**PLANNING ACT 2008 AND THE INFRASTRUCTURE PLANNING  
(EXAMINATION PROCEDURE) RULES 2010**

**APPLICATION (“THE APPLICATION”) BY HIGHWAYS ENGLAND (“THE  
APPLICANT”) FOR AN ORDER (“THE ORDER”) GRANTING  
DEVELOPMENT CONSENT FOR THE A303 SPARKFORD TO ILCHESTER  
DUALLING (“THE PROPOSED DEVELOPMENT”)**

**REQUEST FOR COMMENTS FROM ALL INTERESTED PARTIES ON THE  
APPLICANT’S RESPONSE TO THE SECRETARY OF STATE’S ‘MINDED  
TO REFUSE’ LETTER**

**SUBMISSION BY SOUTH SOMERSET BRIDLEWAYS ASSOCIATION  
 (“SSBA”)**

FIGURE 2.5  
HAZLEGROVE JUNCTION UNDERBRIDGE  
GENERAL ARRANGEMENT

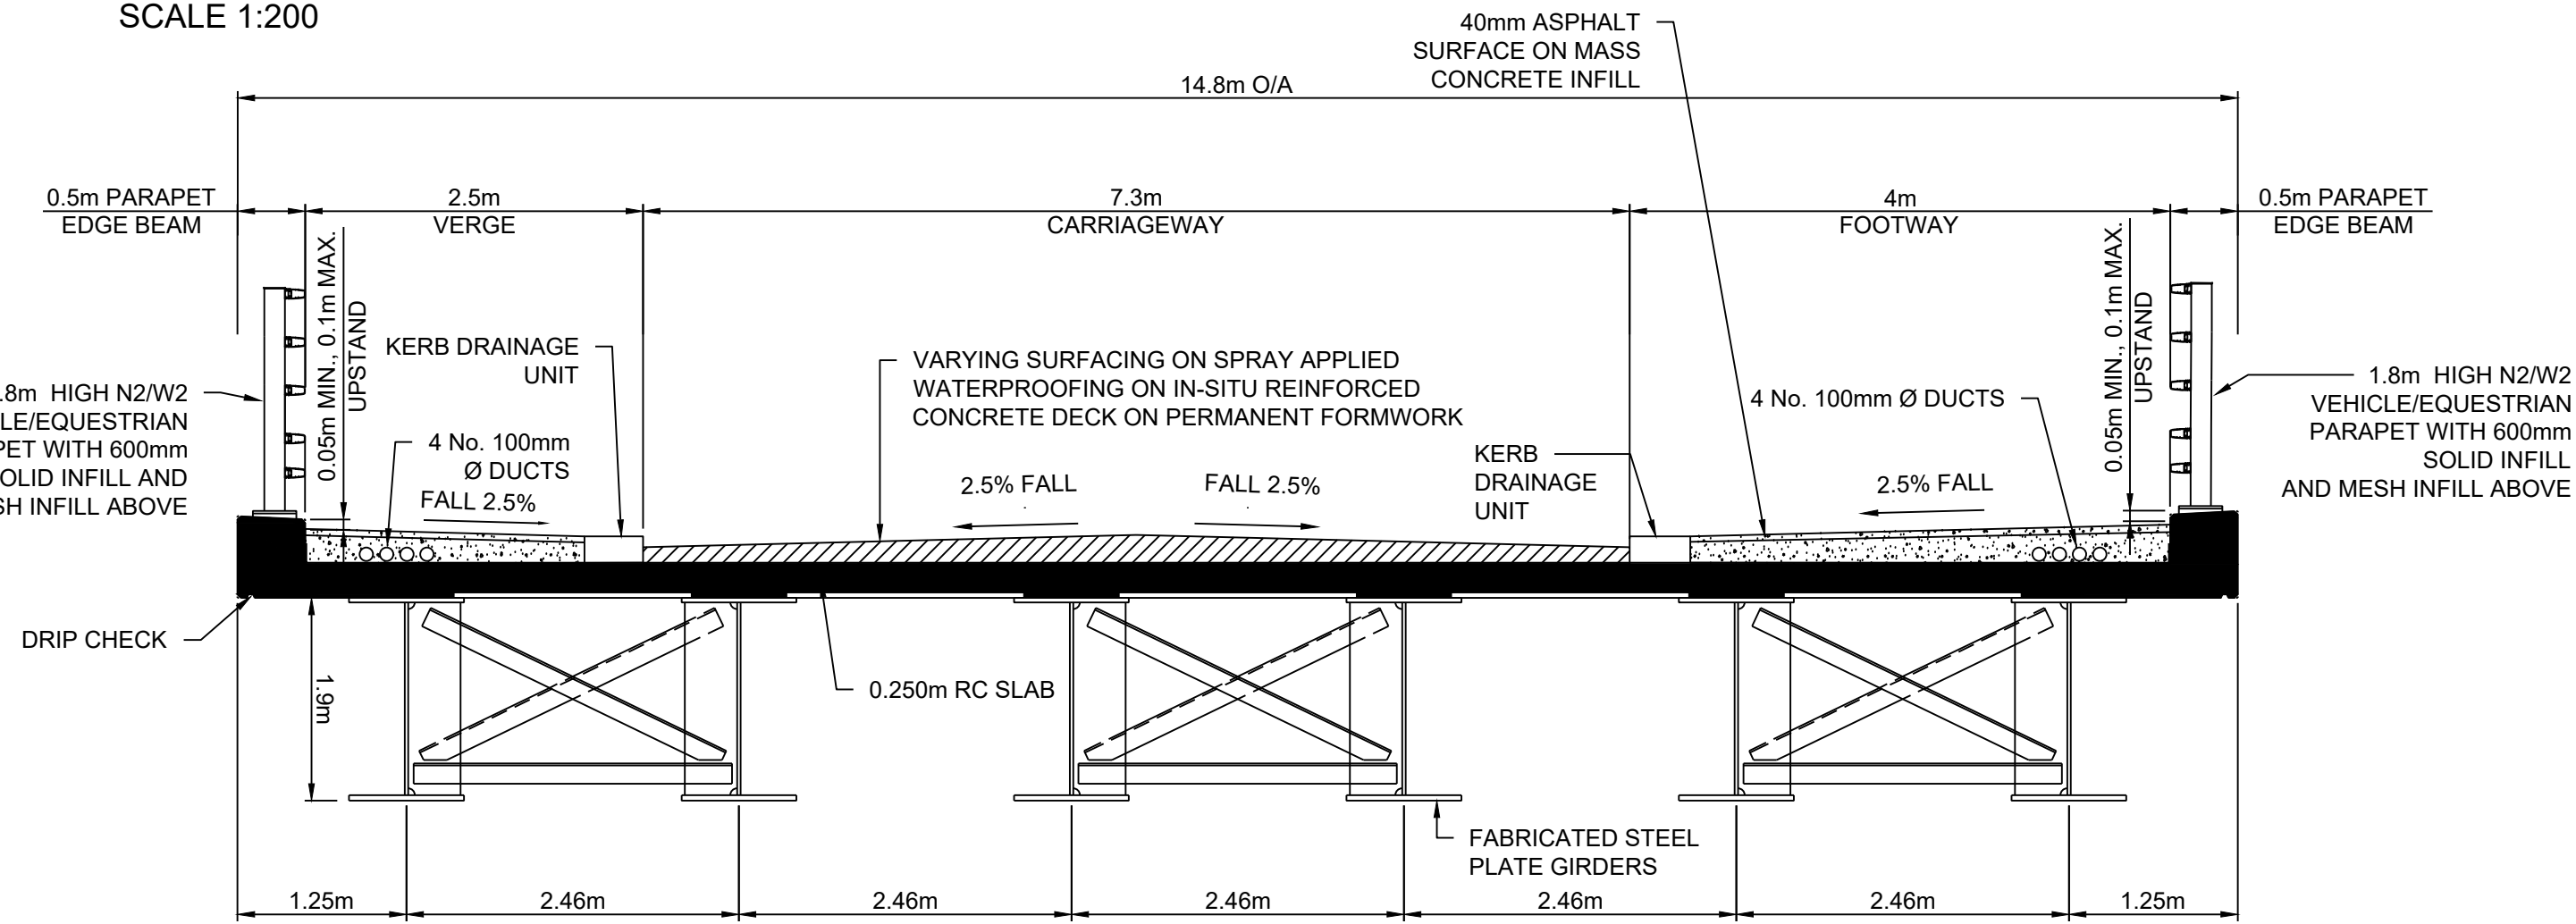
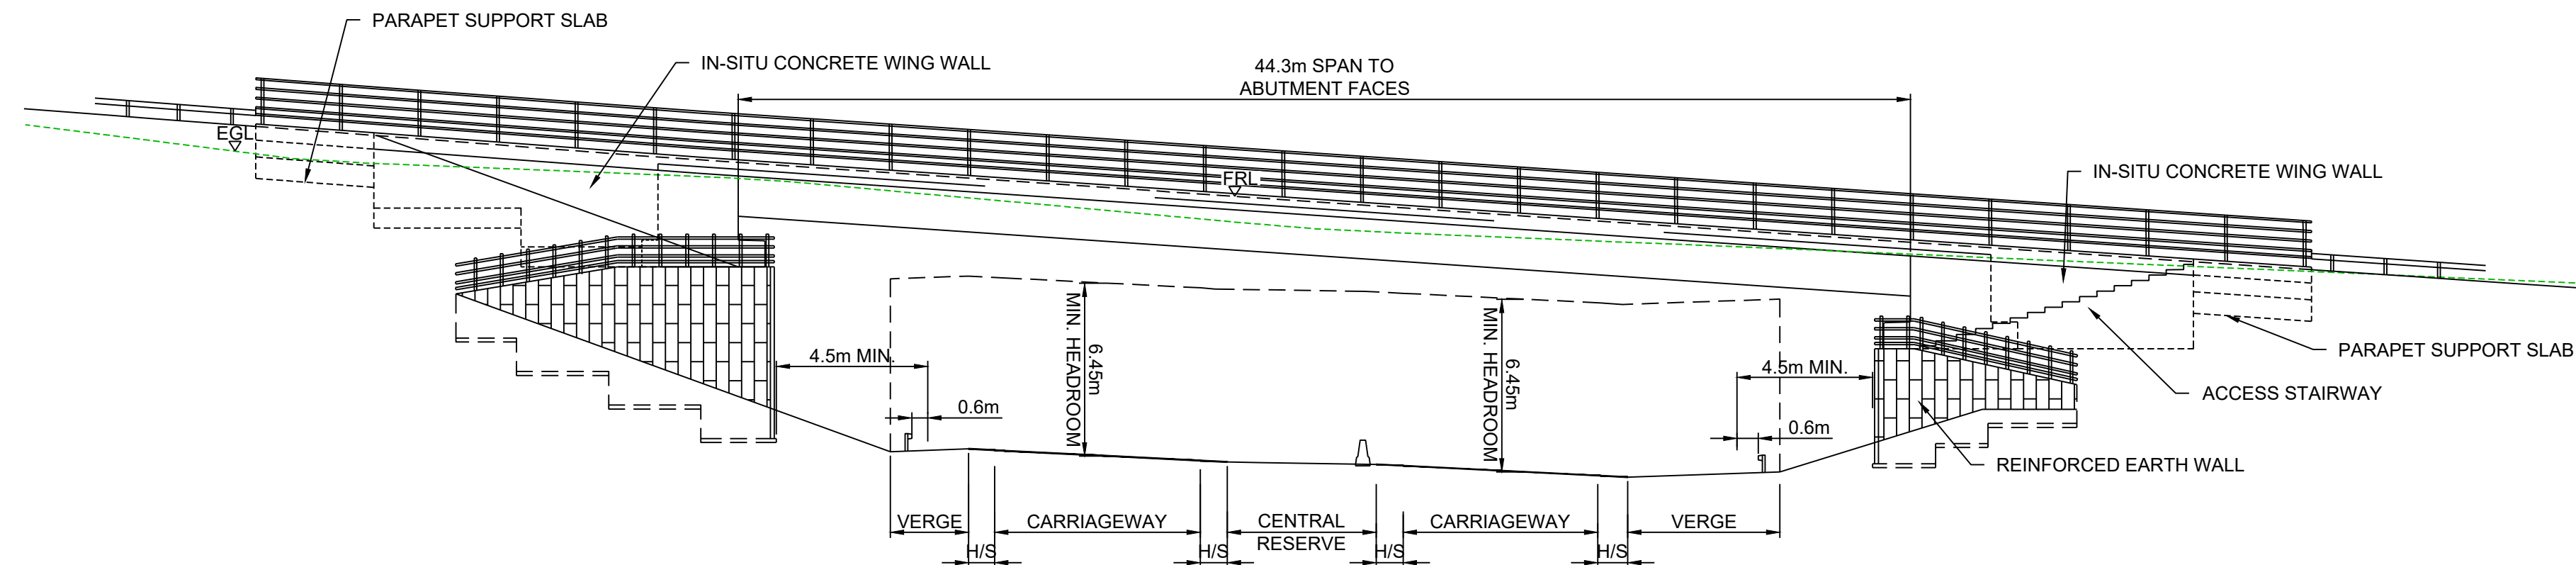
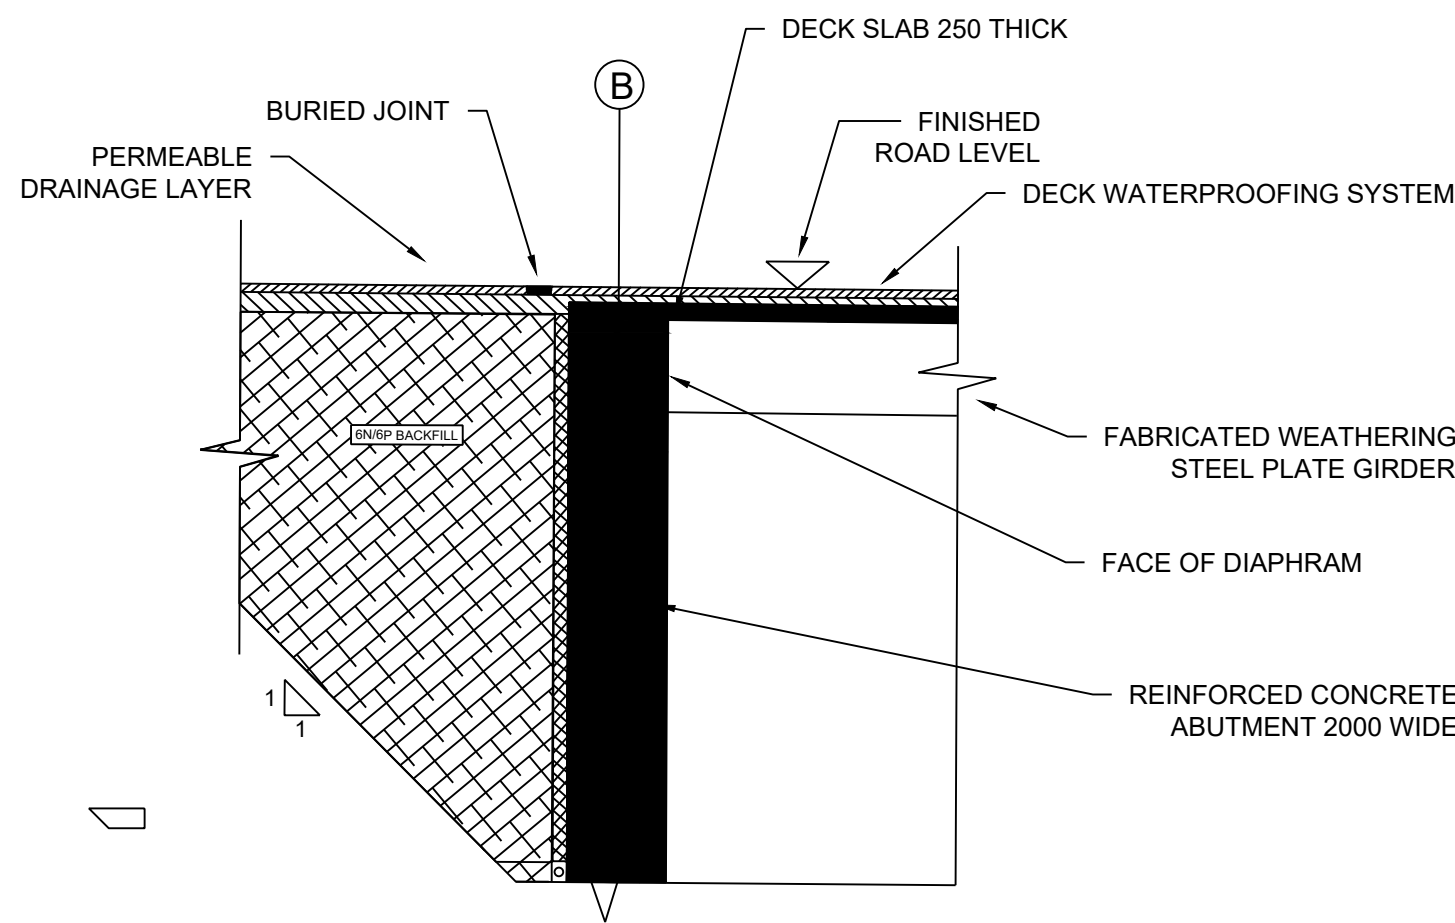
SSBA agrees with the ExA's finding that the Applicant's proposals with respect to lighting of the proposed new underbridge are inadequate and fail to meet the needs of NMUs. SSBA is pleased that the Secretary of State is minded to agree that night-time lighting, on the approaches as well as in the underpass itself, is a reasonable step that is essential to minimise the risk of road casualties and improve road safety and, accordingly, to agree with the ExA's recommended change to the DCO.

SSBA notes that the Applicant has not disclosed the internal dimensions of the proposed underbridge nor the materials to be used in its construction. SSBA considers the NMU route should be separated from the motorised vehicular carriageway(s) and screened to protect NMUs from vehicle lights and noise in the underpass. Without such protection, NMUs (especially equestrians) are at risk of being distracted, causing a road safety risk for all users. The internal dimensions should therefore be a minimum of 5 meters wide and 3.5 meters high exclusive of screenings. Ideally, the NMU route should pass through a separate side tunnel with an anechoic inner surface. This would substantially mitigate the safety risks for both NMUs and motorised traffic and improve the attractiveness of the route for NMUs.

At approximately 25 metres, the underbridge will be unusually long. It is therefore especially important to make it as attractive as possible for NMUs.

Appendix 1 APPROPRIATE MITIGATION FOR STOPPING UP OF TERMINUS OF BRIDLEWAY Y 30/28 (EASTMEAD LANE)

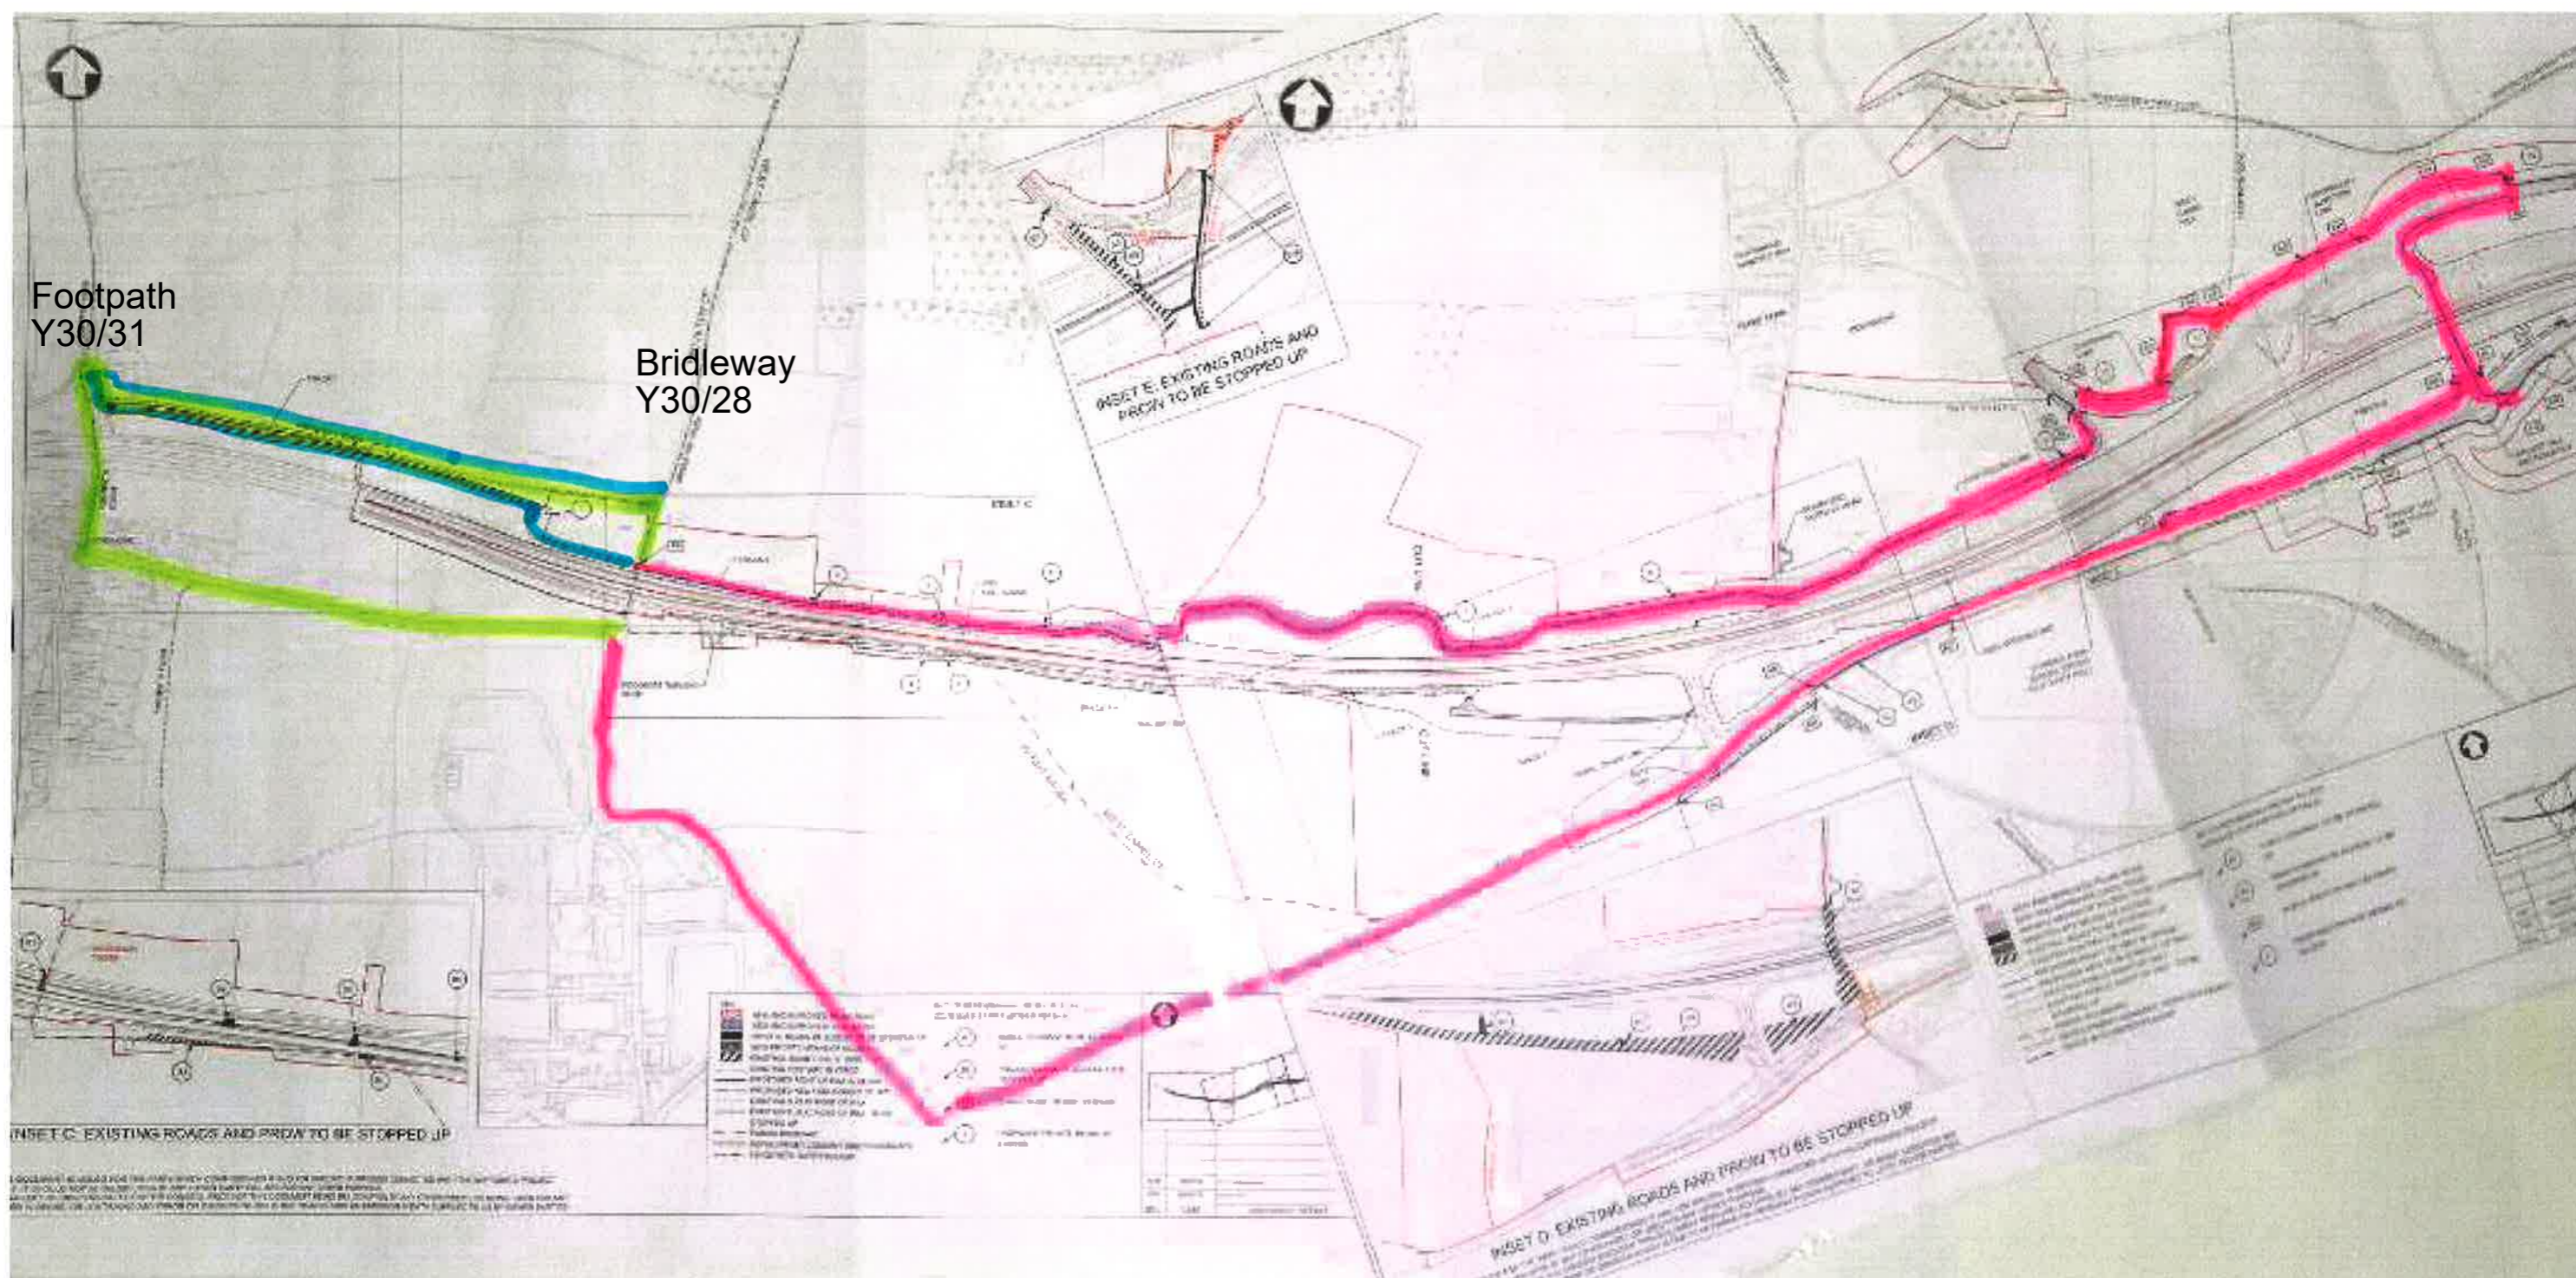
SSBA considers the Applicant's proposed mitigation to be unrealistic and wholly unsatisfactory. In SSBA's opinion, a diversion of this length is unreasonable and may be expected to deter NMUs from using the Eastmead lane (Y30/28) definitive route or encourage them to take unnecessary risk by crossing at grade.

SSBA is therefore pleased that the Secretary of State has taken note of the more effective mitigation we have proposed jointly with South Somerset District Council (SSDC) and Somerset County Council

(SCC) to provide an alternative NMU route over the Higher Farm Lane overbridge. This would involve a detour of only 1.5 kilometres, and could be readily delivered by:

1. The Applicant dedicating restricted byway rights on a suitable route within the DCO boundary from Eastmead Lane to Higher Farm Lane; and
2. SCC making the requisite orders to record the restricted byway rights along Higher Farm Lane (including the overbridge) pursuant to the outstanding DMMO application (SCC reference 863M) and to connect the route in 1. above to Higher Farm Lane.

Appendix 2 POTENTIAL LEGACY ISSUES IF ONLY PARTIAL REVOCATION OF 1996 SRO

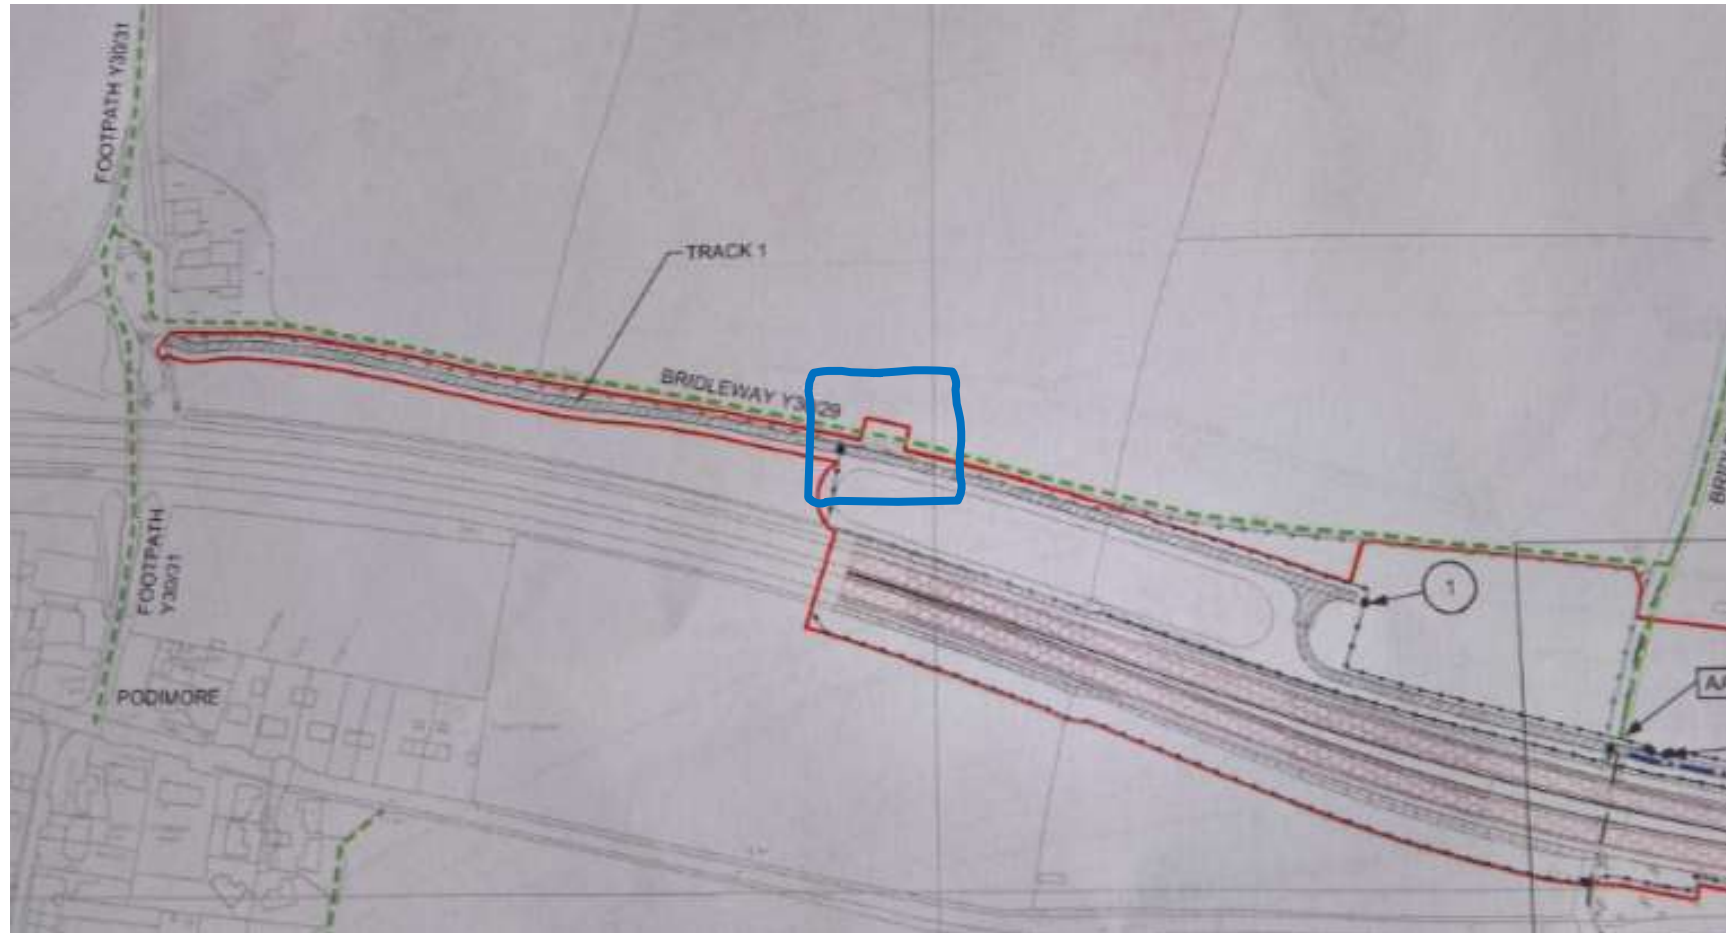
This proposal, if implemented, would have the additional benefit of resolving the failure to deliver bridleway Y30/29 in accordance with the 1996 Side Roads Order.
